EPC STORMWATER REVIEW COMMENTS  
IN ORANGE BOXES WITH BLACK TEXT

STATE OF COLORADO  
DEPARTMENT OF TRANSPORTATION  
CITY OF COLORADO SPRINGS  
Parks, Recreation and Cultural Services Department  
CAPITAL IMPROVEMENT PROJECT  
TRAIL IMPROVEMENT PROGRAM  
COMBINED FEDERAL AID PROJECT No. TAP M240-162, SubAccT. No.20391  
**GRADING AND EROSION CONTROL**  
PLAN of the ROCK ISLAND MULTI-USE TRAIL  
SAND CREEK TO CONSTITUTION AVENUE  
COLORADO SPRINGS & EL PASO COUNTY, COLORADO

21 JULY 2024

Kiowa Proj. No. 16028
TAP M240-162
SubAcct No.20391
Sheet Number GEC 1

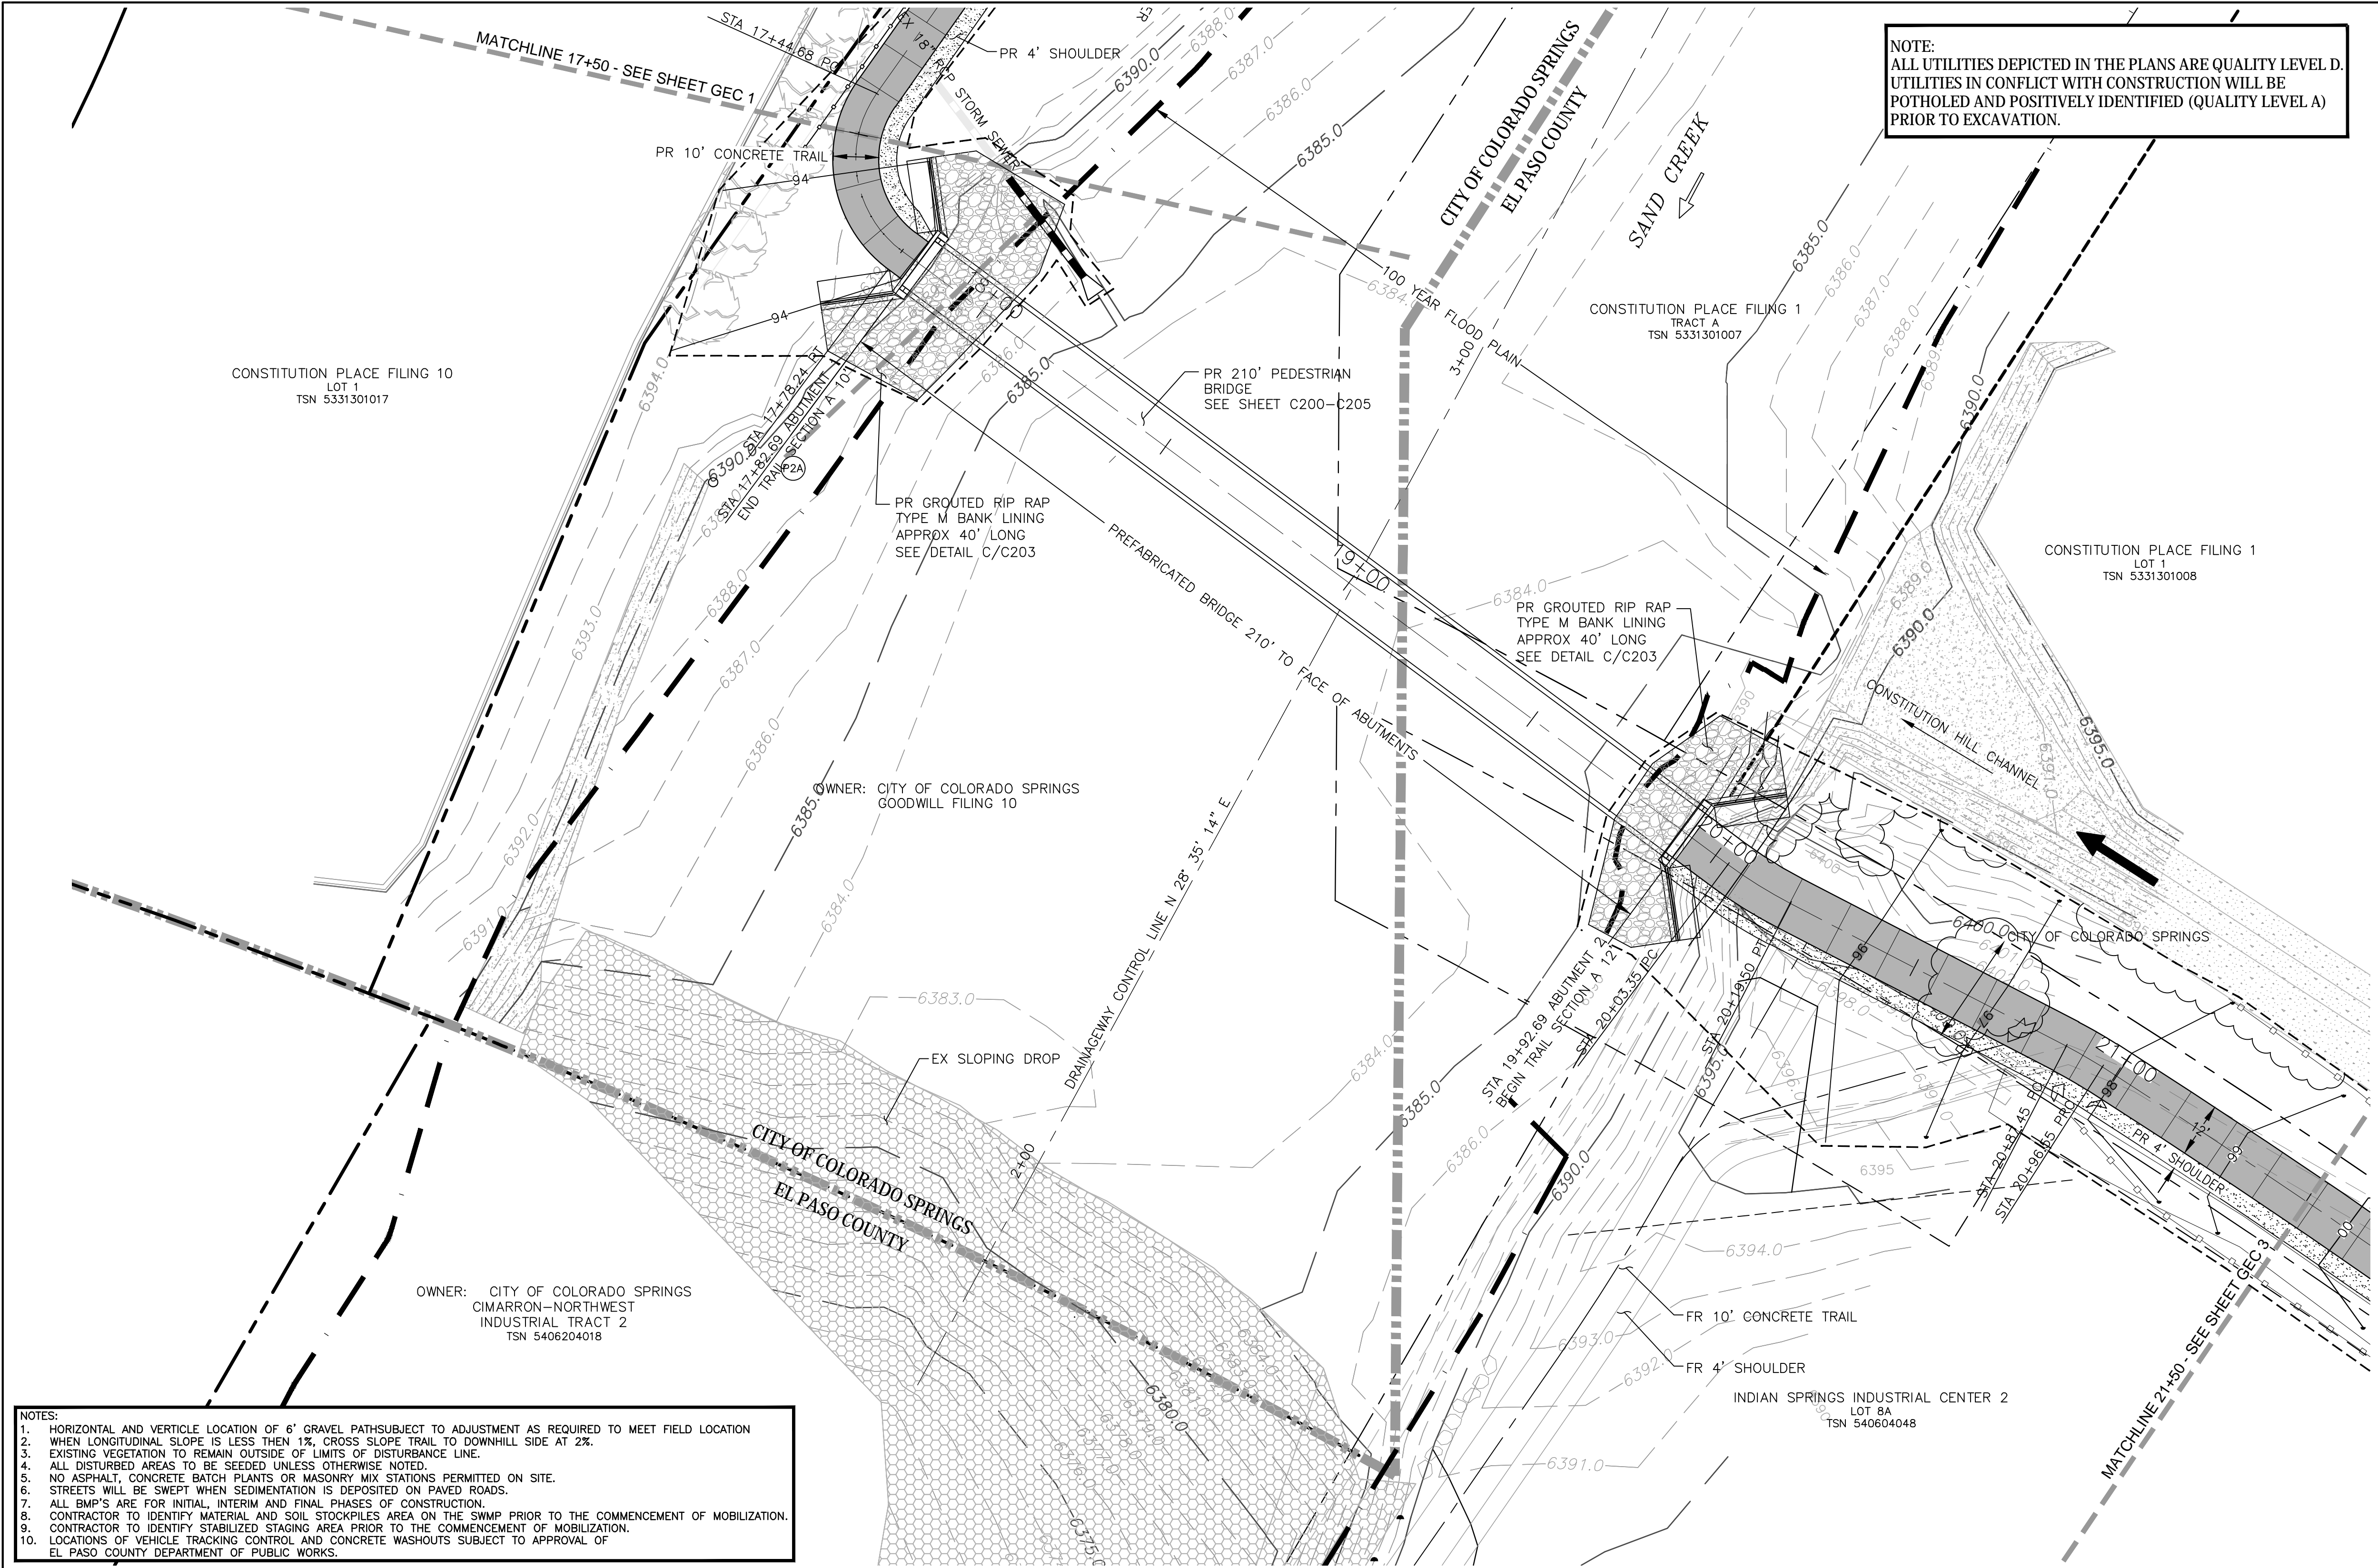
These construction sheets should also have BMPs, VTC, etc. These sheets don't appear to showing erosion control items. All items including flow arrows, cut/fill, BMPs, etc should be on all areas of disturbance.
